# SDRP RESPONSE

## State Design Review Panel – 9<sup>th</sup> December – First Review

## State Design Review Panel – 25<sup>th</sup> May 2022 – Second Review

project			
2A GREGORY PLACE HARRIS PARK			
checked	FS	drawing	SUN EYE VIEW DIAGRAMS - WINTER SOLSTICE 1130
drawn	JN	issue	B
project no	14 004	drawing no	CD 6007

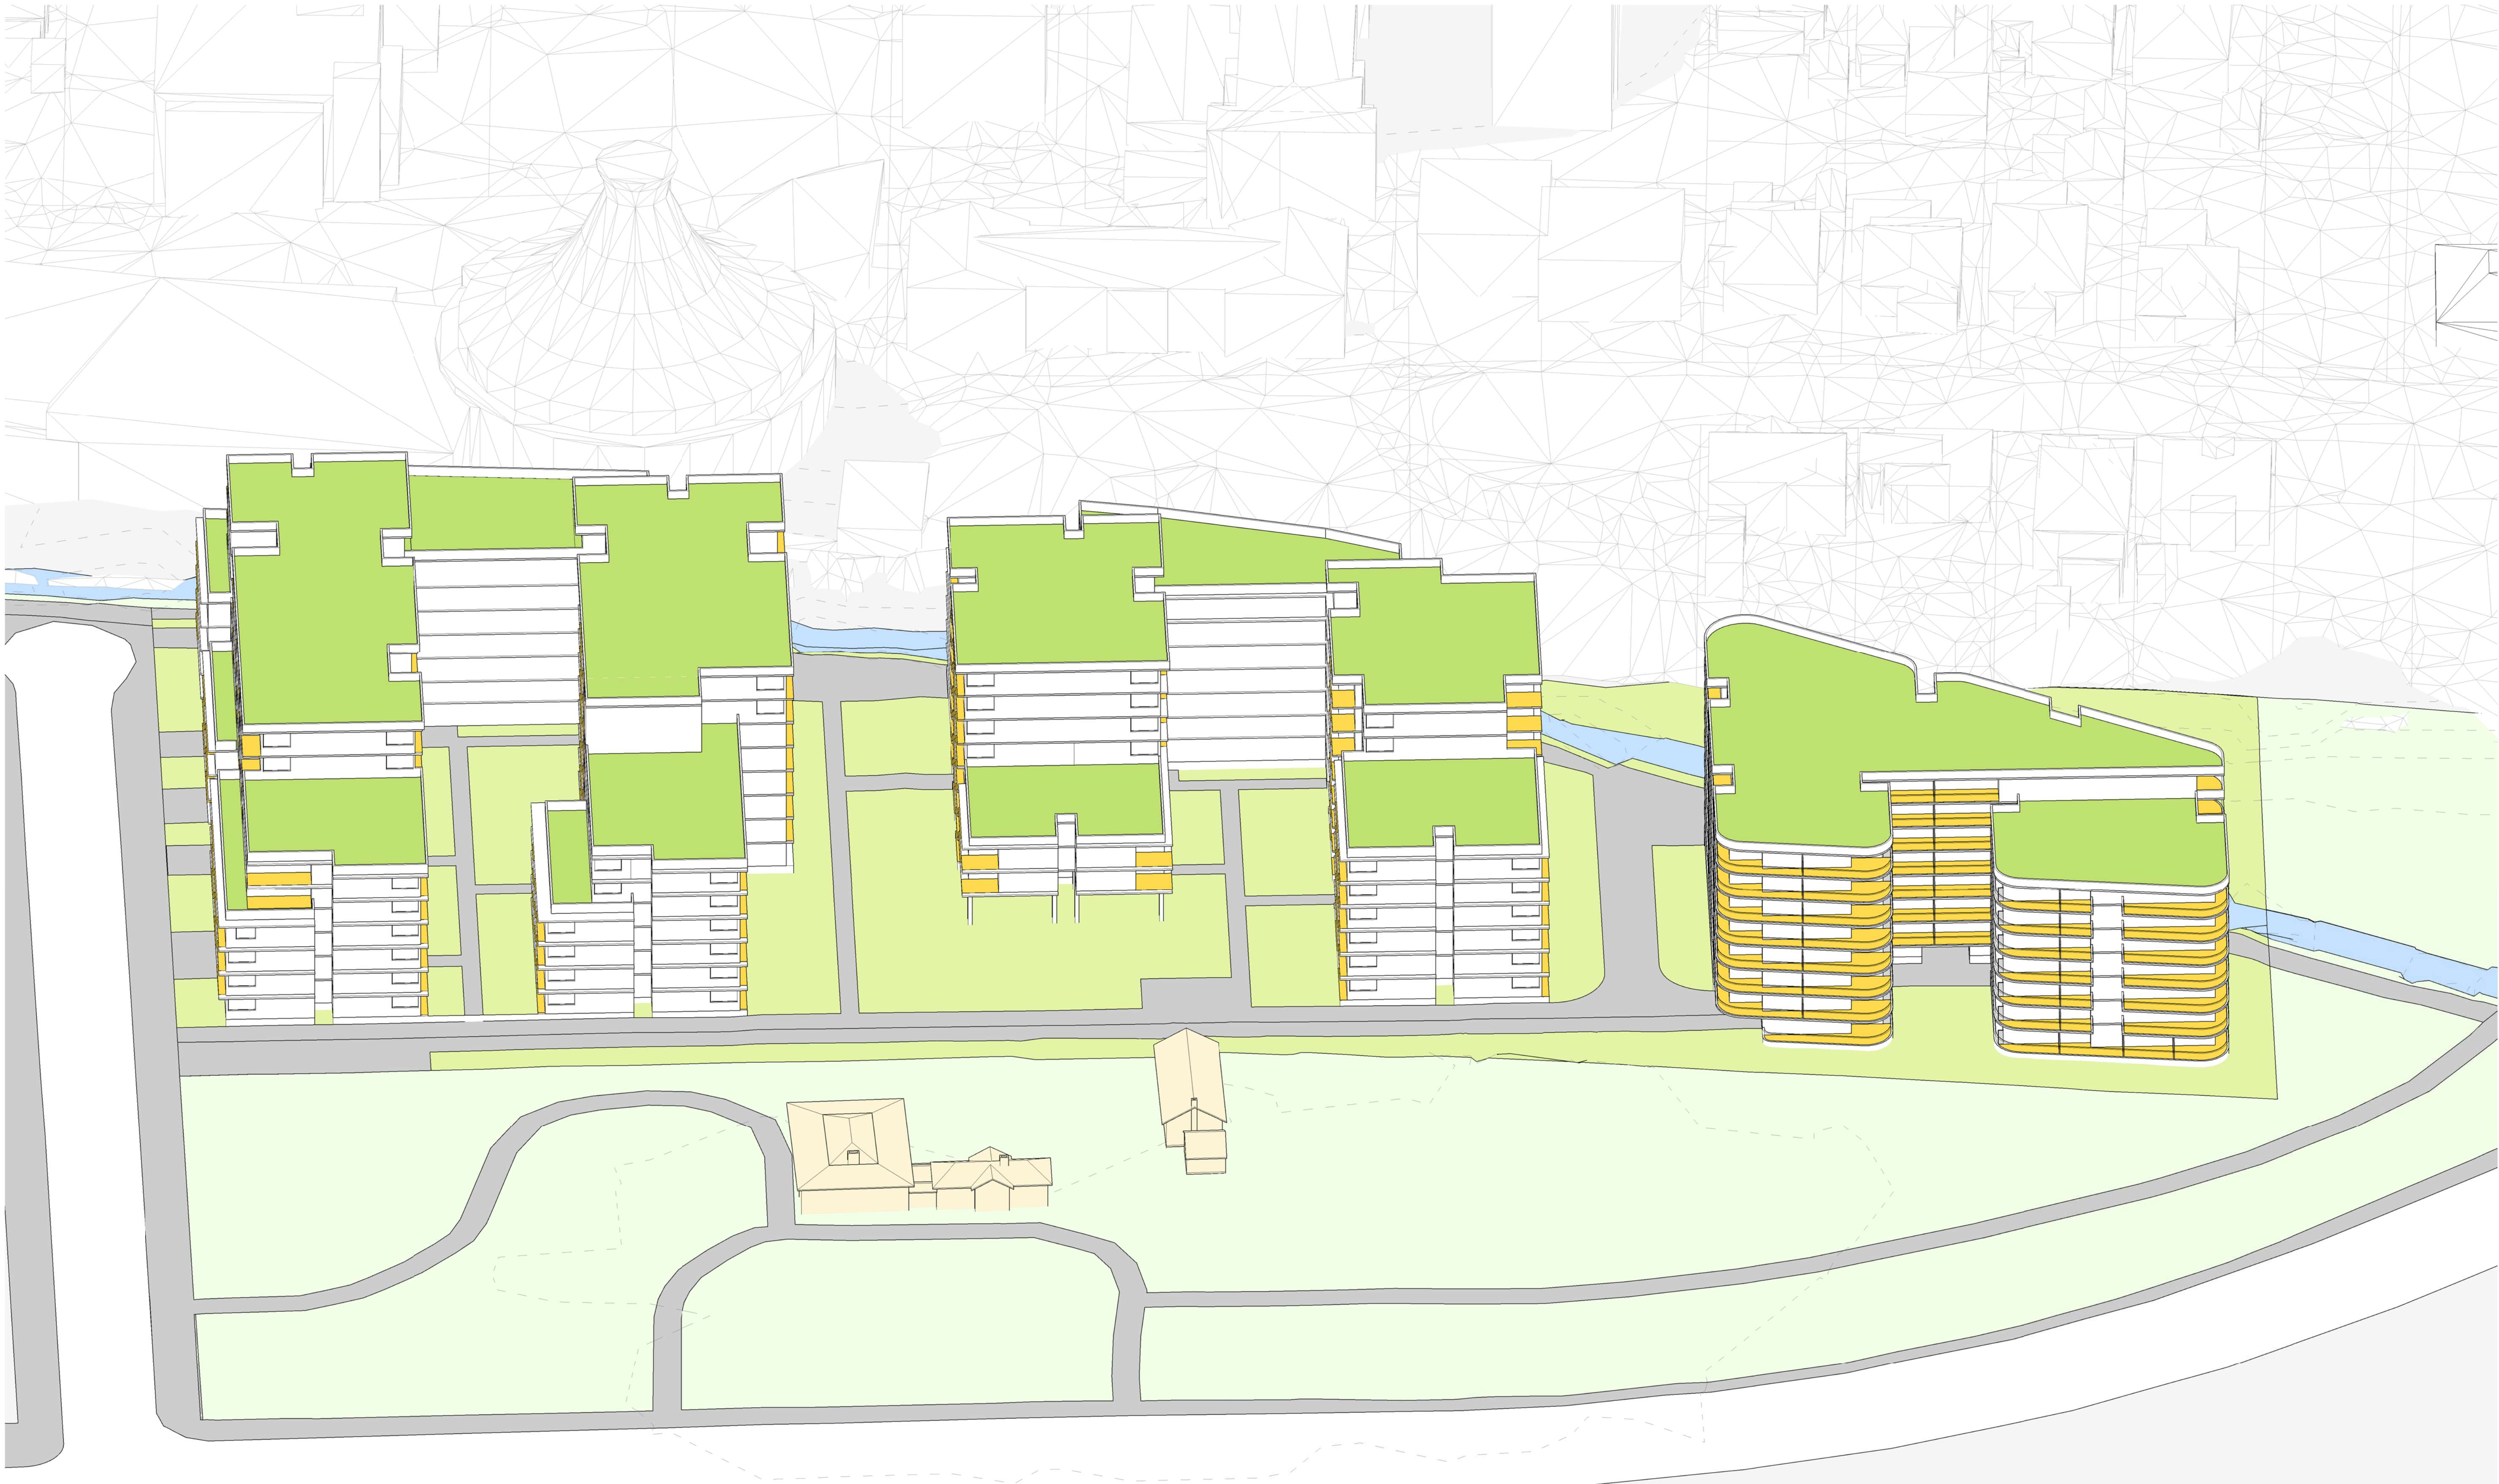
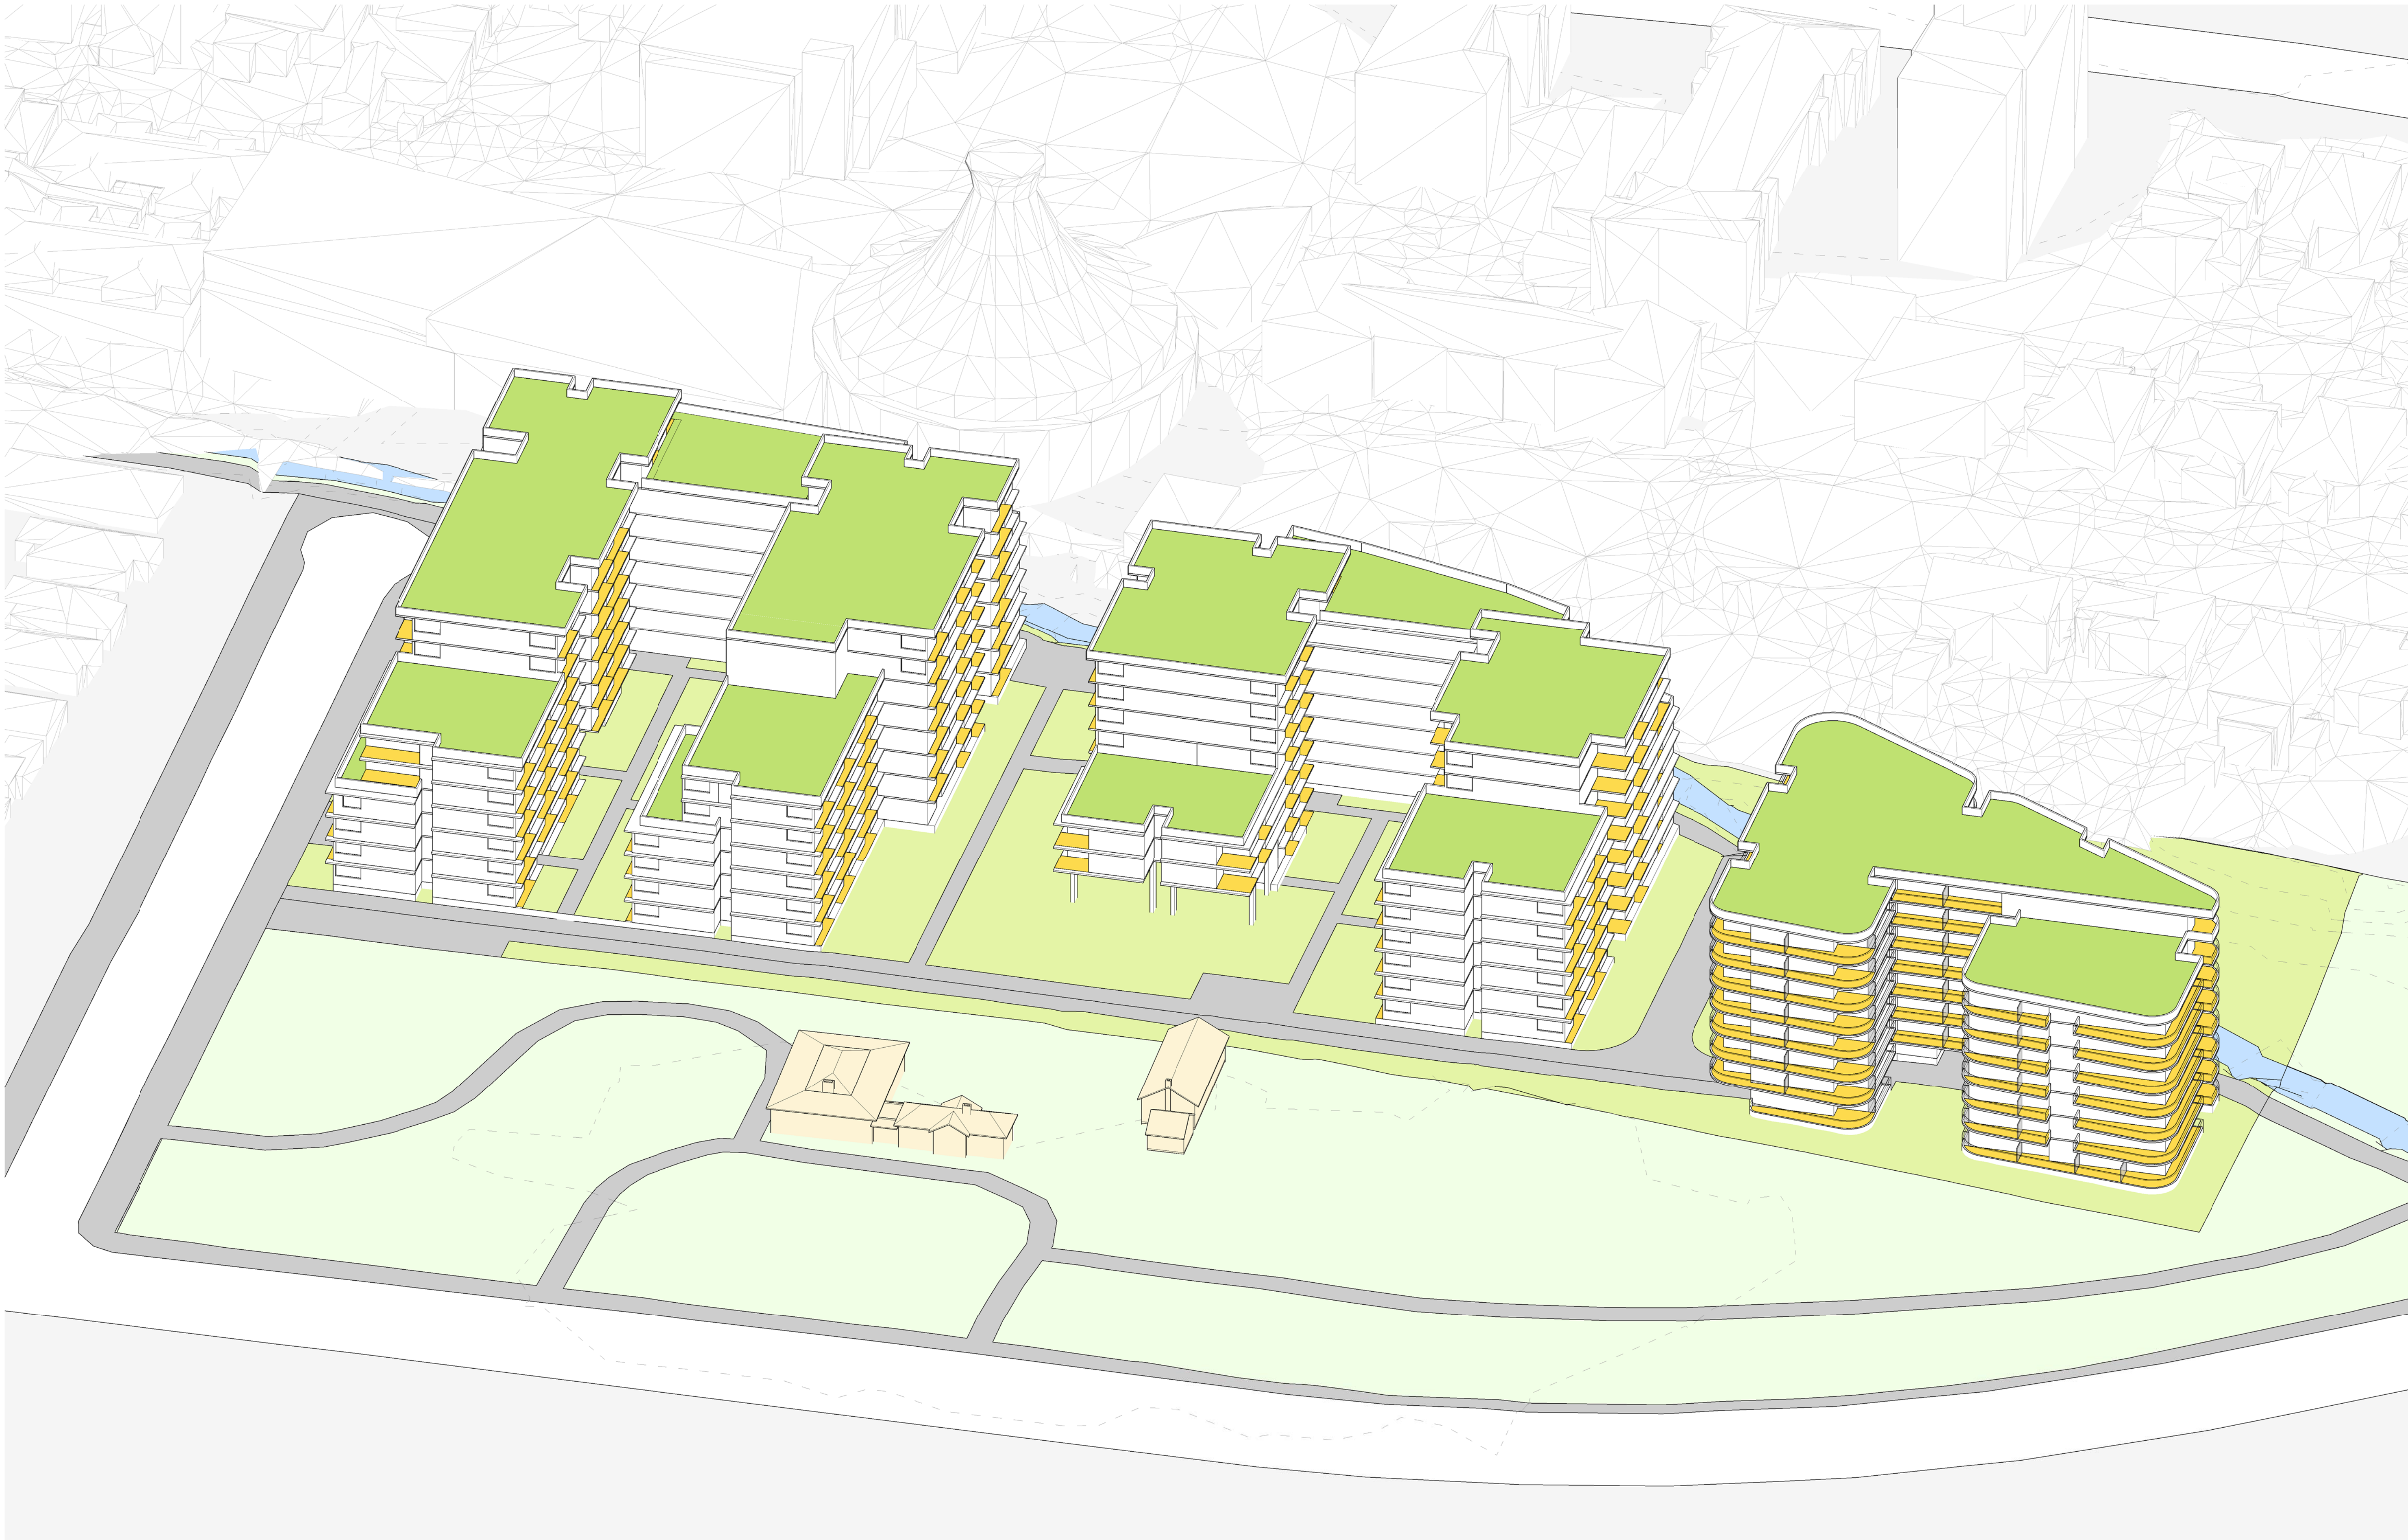
SDRP Comment	Project team's response
	<p>The sun eye view diagrams illustrate that at mid-winter:</p> <ul style="list-style-type: none"> <li>• Passage 1 receives direct sunlight between 9.30am to 2.00pm.</li> <li>• Passage 2 received direct sunlight between 10.15am to 1.30pm.</li> </ul> <p>The benefit of locating taller buildings along the stormwater channel is that the publicly accessible pathways and communal courtyards to the north of site receive direct sunlight throughout the day at the winter solstice.</p> <p>The Landscape Concept Plan prepared Taylor Brammer Landscape Architects includes detailed cross sections through the channel walk to describe the spatial characteristics and includes indicative planting palette illustrating that the natural light levels achieved can sustain healthy growth of planting which supports the vision for the site to rejuvenate the blighted industrial land and to better Connect with Country.</p>

SDRP comment		Project team's response
c	<i>Undertake sun eye view analysis as part of the resolution of the private and public open spaces including along the creek corridor to ensure they receive adequate natural light all year round.</i>	<p>The architectural drawings prepared by Stanisic Architects incorporate a sun eye view and shadow diagram analysis of the proposal to confirm the impact of the proposed built form and to understand the direct sunlight achieved to the Channel Walk at the winter solstice.</p> <p>Refer to SDRP First Review – Response 1.</p>
d	<i>Review the spatial quality and appropriateness of the deep proportions of Courtyard A and relationship with surrounding built form.</i>	<p>The architectural design concept is for 3 x freestanding building forms that are arranged into an orthogonal layout of five fingers that vary in height from 4-8 storeys and adjust to the scale of the existing and future context, including remaining colonial cottages. The built form has been embedded within a parkland setting of courts and passages that creates a framework for permeable pedestrian movement to enable physical and visual connections to the rich cultural landscape setting.</p> <p>The built form has been modified during extensive consultation with the Heritage Council who provided their support for extending the grid of Harris Park onto the site and creating a large open space directly behind Hambledon Cottage to transition from the low-rise cottage to the taller forms along the stormwater channel and interpret the location of Neale's Cottage that once stood on the site. A key guiding principle from a heritage perspective was to achieve a large open space behind the cottage that provides a clear spatial transition between properties.</p> <p>Building A is a u-shaped building with heights that vary from 6-8 storeys with significant modulation within the internal courtyard space that reduces the length of walls and creates a number of spaces within the north facing courtyard. As a consequence, Building A achieves very different characteristics to Building B + C which is desirable and has been encouraged by the SDRP.</p> <p>The Concept Envelope has been modulated to achieve a high level of amenity for occupants as well as ensuring compatibility with the surrounding context. There is no need or basis to further "break down" the floor plates or "reduce their size" as the key guidelines of the Apartment Design Guide (solar access, natural cross ventilation, deep soil, communal open space and building separation) are all achieved and in most cases greatly exceeded.</p>
